**KIRKLEES METROPOLITAN COUNCIL
INVESTMENT & REGENERATION SERVICE**

DELEGATED DECISION TO DETERMINE PLANNING APPLICATIONS

Reference No: 2020/62/93467/W

Description: Erection of gates and gate posts

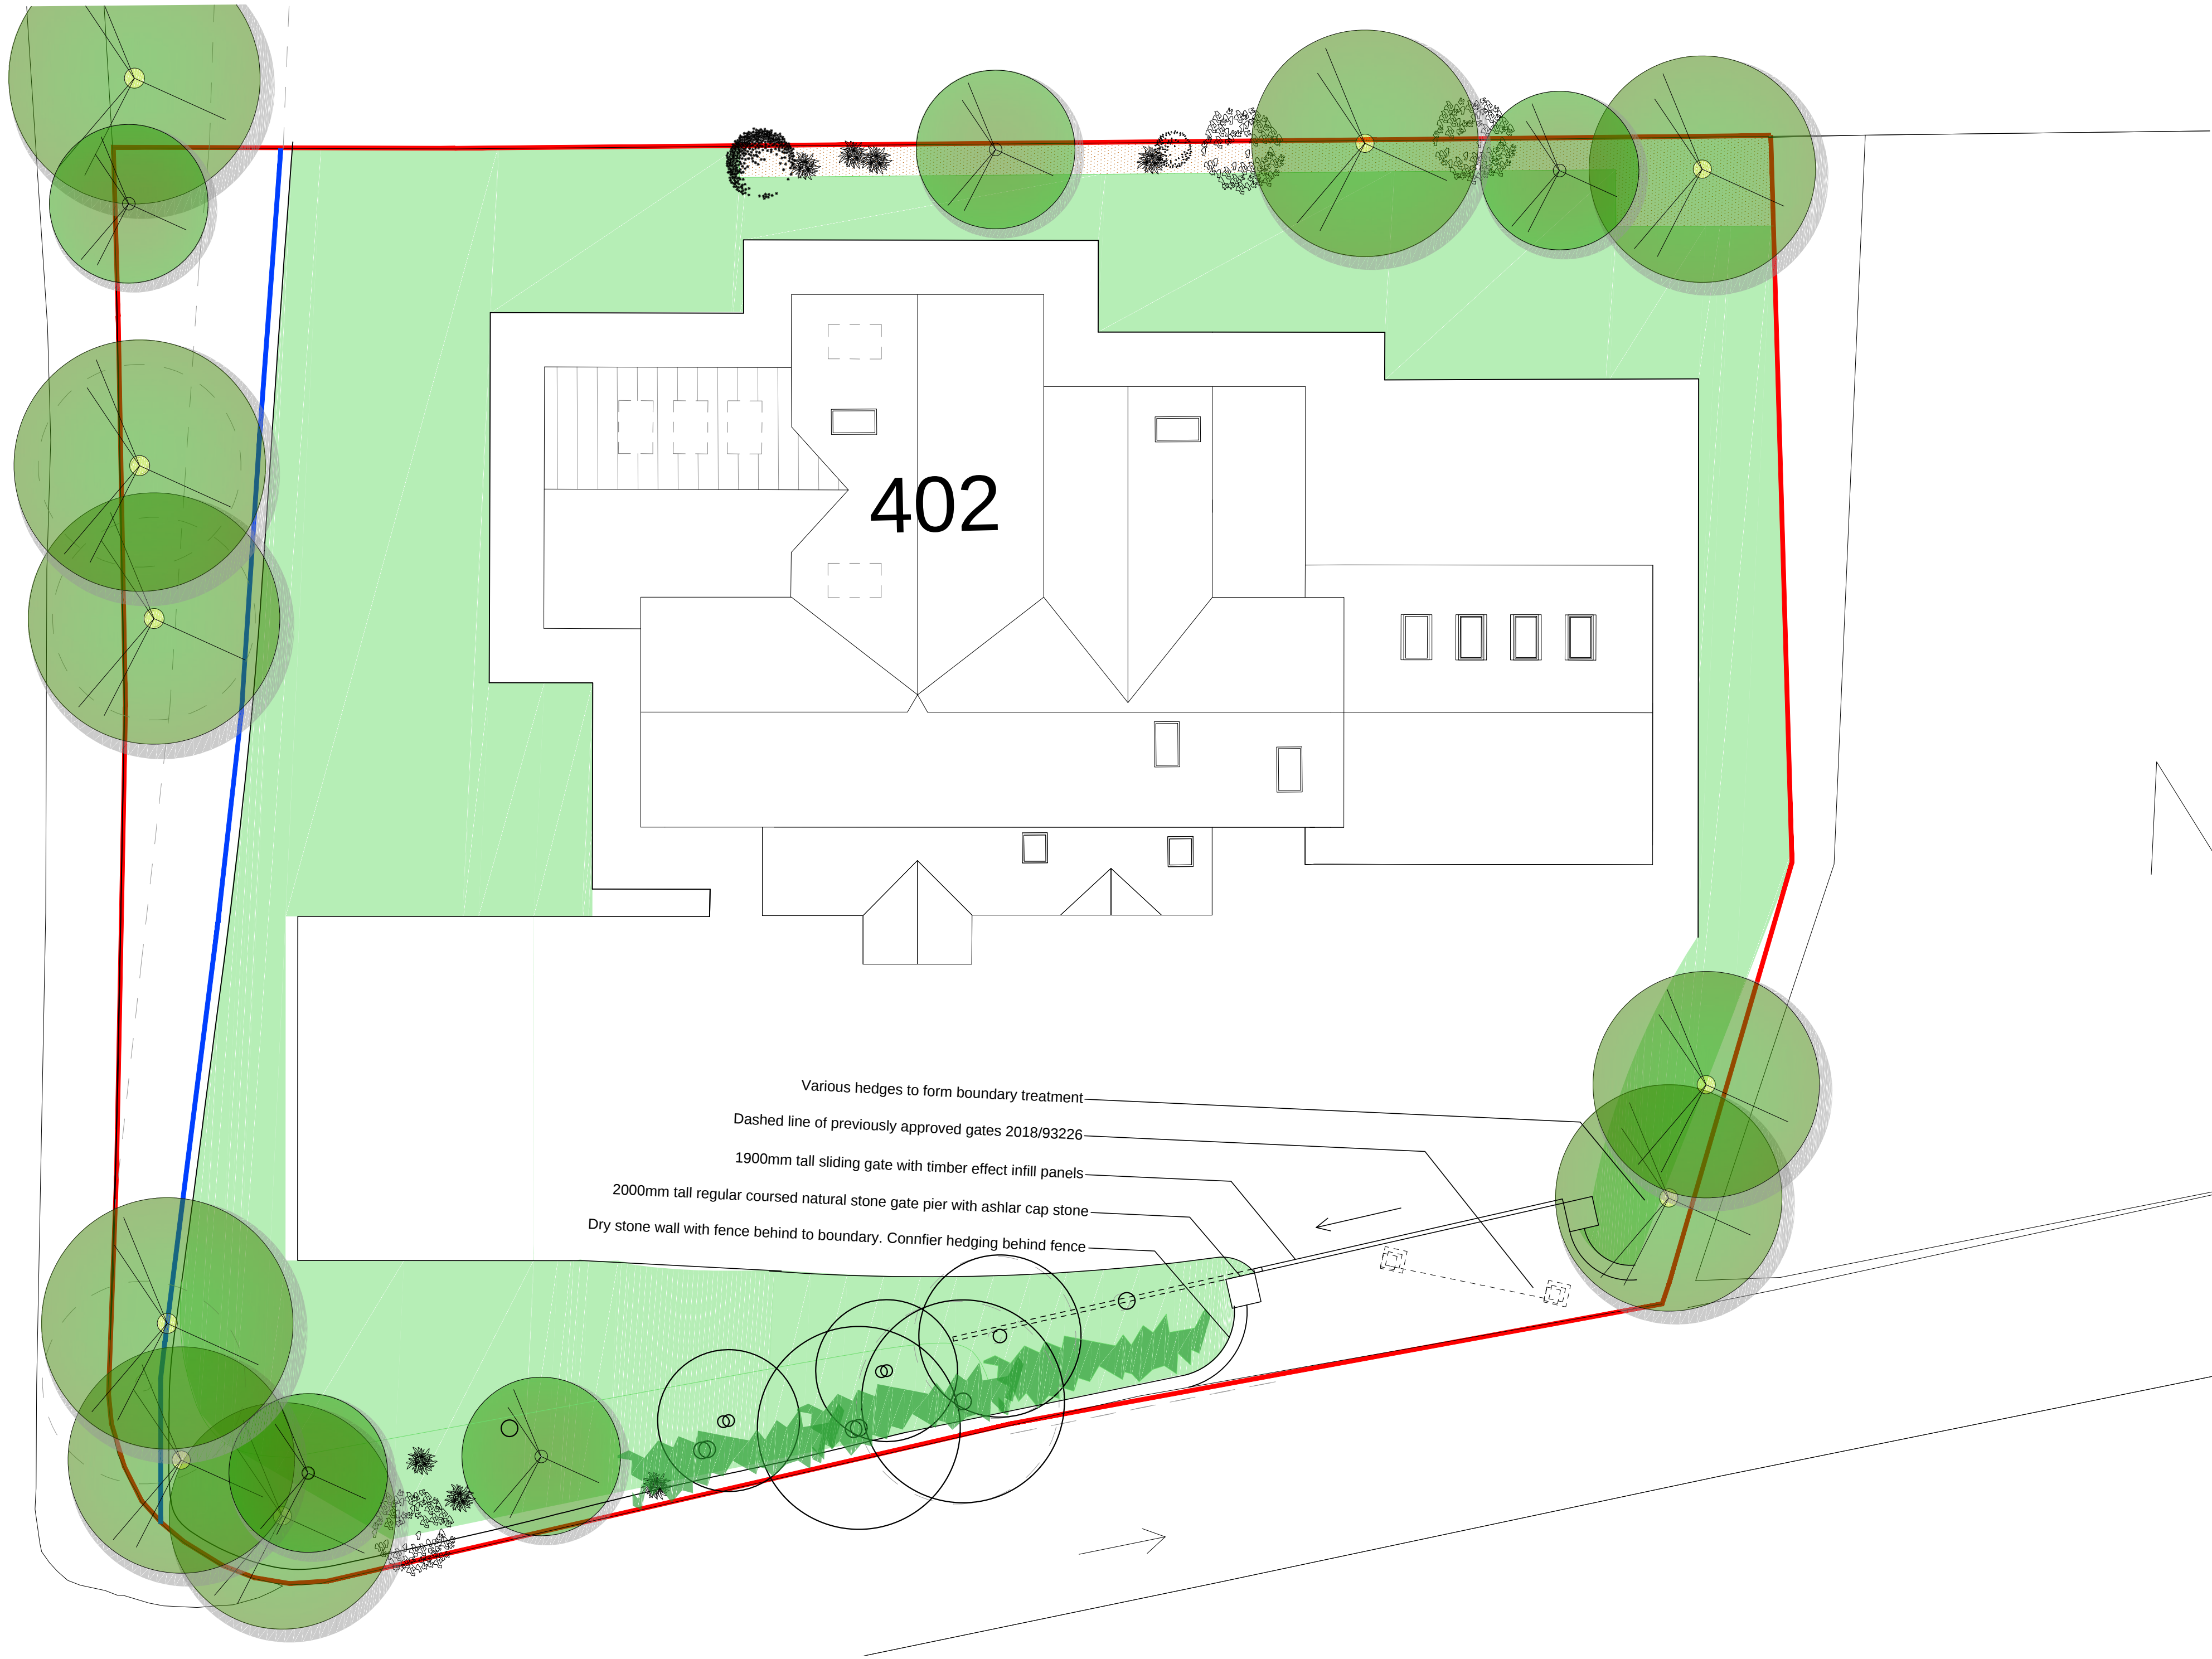
The case officer secured amended plans which reduce the scale of the gate from 2.3 to 2 metres and reduced posts from 2.5 metres to 2.15.

The new gated entrance whilst substantially larger than the original opening is considered to be of an acceptable size when the context of the site is assessed. The plot along the access has a total length of approximately 38 metres and the 7.6 metre wide opening is not considered to detrimentally dominate the site in design terms. The gate whilst larger than the original scheme, at 2 metres high is the same height as typical boundary treatment that can be undertaken under permitted development and whilst slightly imposing in its appearance would be read in the context of the overall site which includes tall boundary treatment including a fence and planting. The gate posts whilst slightly higher at 2.15 metres are only marginally taller and would also be read in conjunction with the wider context at the site.

With regard to appearance, the gate posts are constructed from natural stone which is in keeping with the host property which is considered to be acceptable. The gate which is metal painted black with a small degree of ironwork at the top is also considered to be acceptable. The composite panels are akin to a typical fence, and whilst having a solid appearance is not considered to be significantly detrimental in the street scene.

The proposed gate and gate posts would operate in sliding mechanism which would require users to wait on the adjacent lane before entering the site. Such an arrangement is similar to the originally gated entrance to the site, but it is noted that the wider opening may require vehicles to wait on the lane for possibly longer. Whilst vehicles would have to wait on the lane, it is not considered to be significantly detrimental to highway safety as the road serves a limited number of properties and the gates are slightly set back from the site boundary allowing a small degree of pull off space. Furthermore given the width of the lane at 4.2 metres which combined with the pull area would provide some degree of passing to occur at low speeds.

Plan Type	Reference	Version	Date Received
Location Plan	2352 - LOCB		13/10/2020
Proposed Plans and Elevations	2352 14 Rev B		4/12/2020
